**State Significant Development (New Tweed Valley Hospital)
and proposed State Environmental Planning Policy
771 Cudgen Road, Cudgen
Notice of Exhibition**

Thank you for your correspondence dated 29 October 2018 inviting Transport for NSW (TfNSW) comment on the above State Significant Development (SSD 9575) Application.

TAB A – Detailed comments on SSD 9575

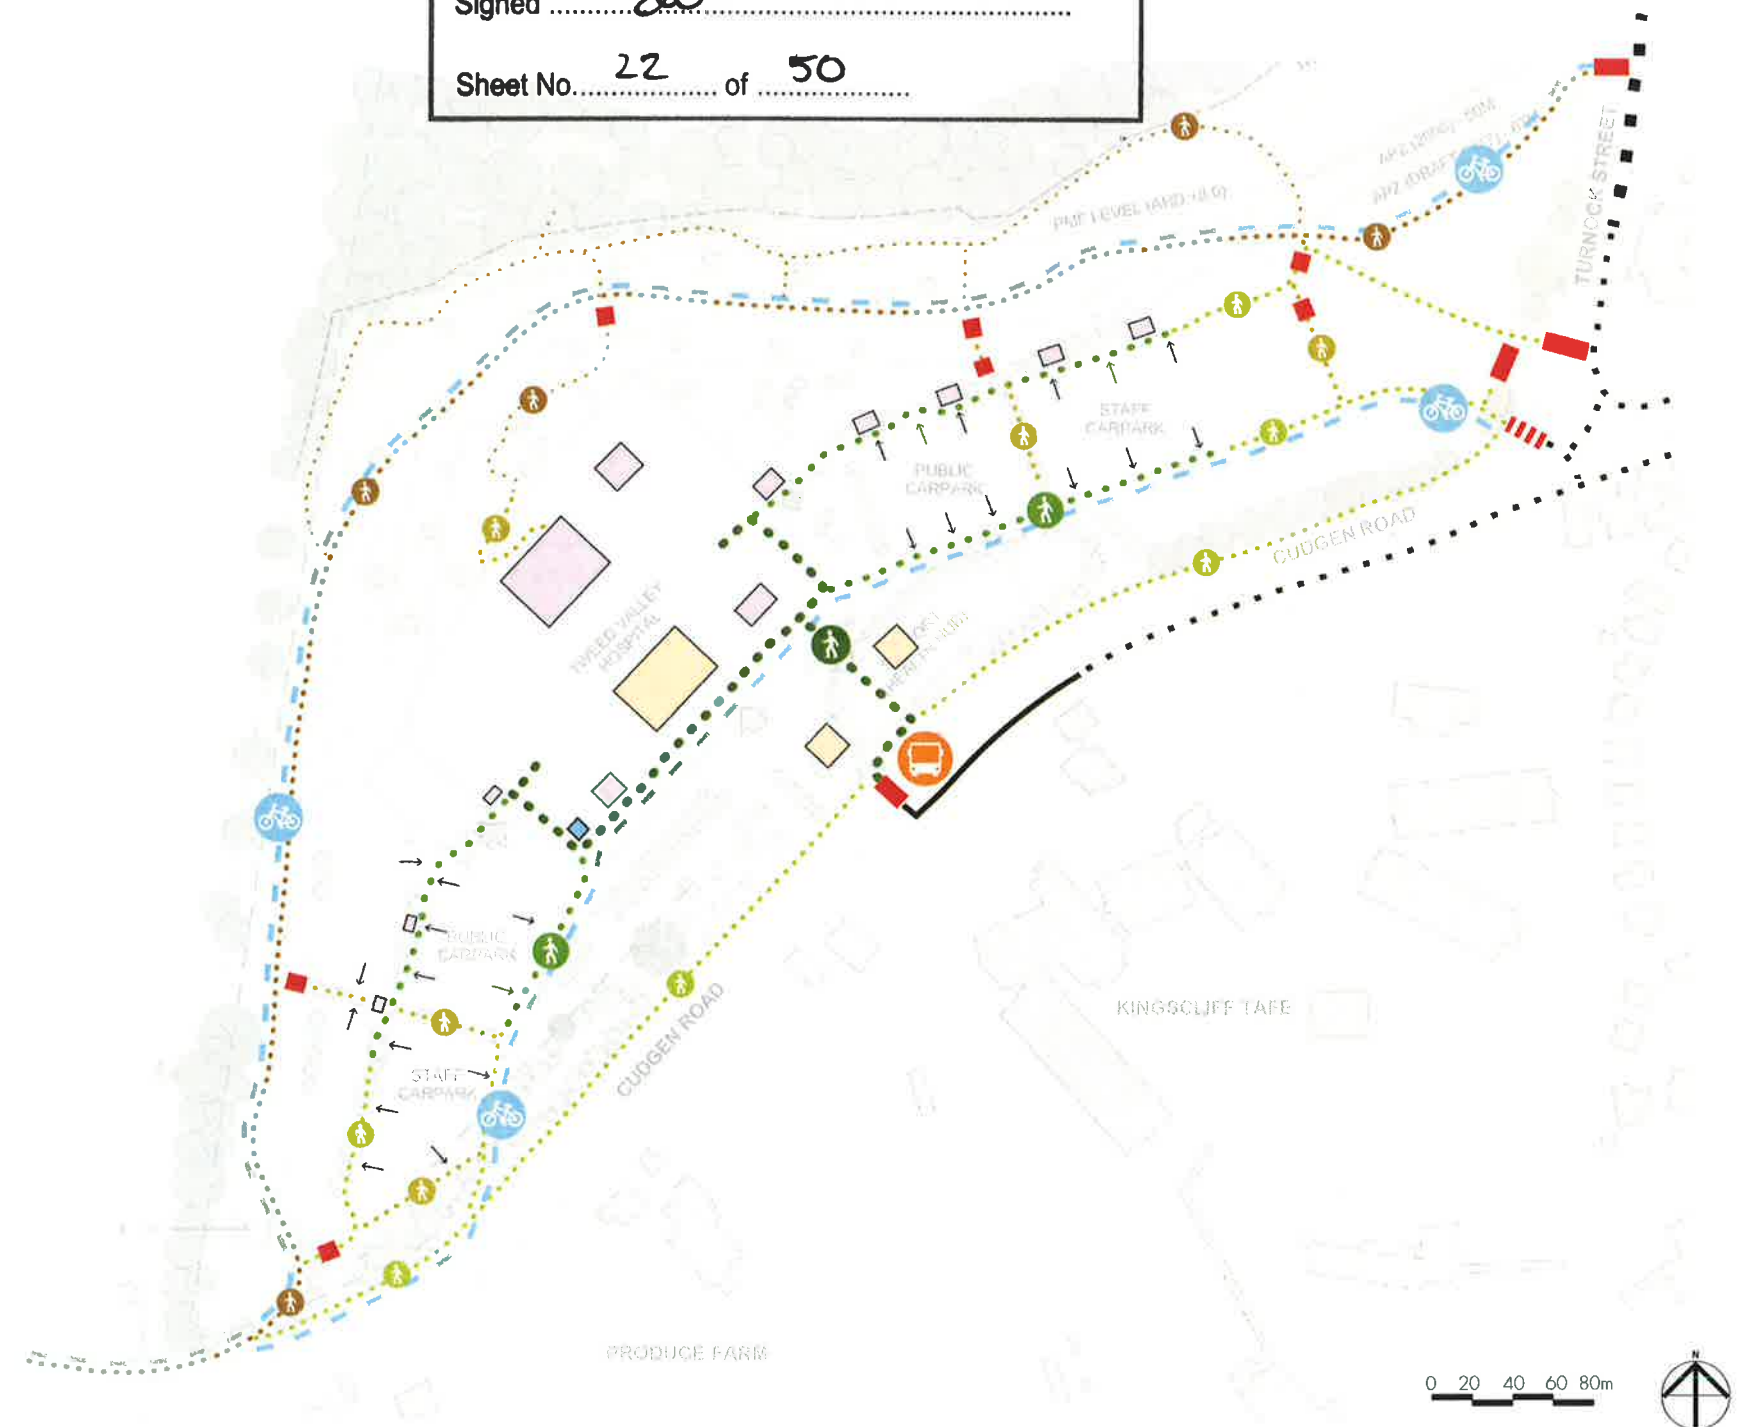
The EIS notes two new bus stops will be provided on Cudgen Road, to the east of the primary signalized intersection. The Master Plan (Drawing No: AR-SKE-10-006) indicates the location of these bus stops. As the proposal seeks approval for the concept plan and Stage 1 works, detailed design of the bus stops have not been provided at this stage, however should be provided in subsequent stages.

Pedestrian access between the hospital and the proposed bus stop within the indented bay on Cudgen Road will need to be provided in accordance with the relevant disability access standards and guidelines.

It is noted that 14 visitor and 29 staff bicycle parking spaces are required based on the Tweed Development Control Plan. The EIS states the concept plans do not show the bicycle parking and that secure bicycle parking, storage and end of trip facilities will be further considered in Stage 2.

Detailed design of the bus stop and a site plan indicating the location of the bus stop and the lay-up zone should be provided in future stages.

These designs should include consideration of distance and grade requirements to comply with disability access standards/guidelines and be carried out in consultation with TfNSW

Future design iterations should illustrate the location bicycle facilities in secure, convenient, accessible areas close to the main entries incorporating adequate lighting and passive surveillance and in accordance with Austroads guidelines and the relevant Australian Standards.
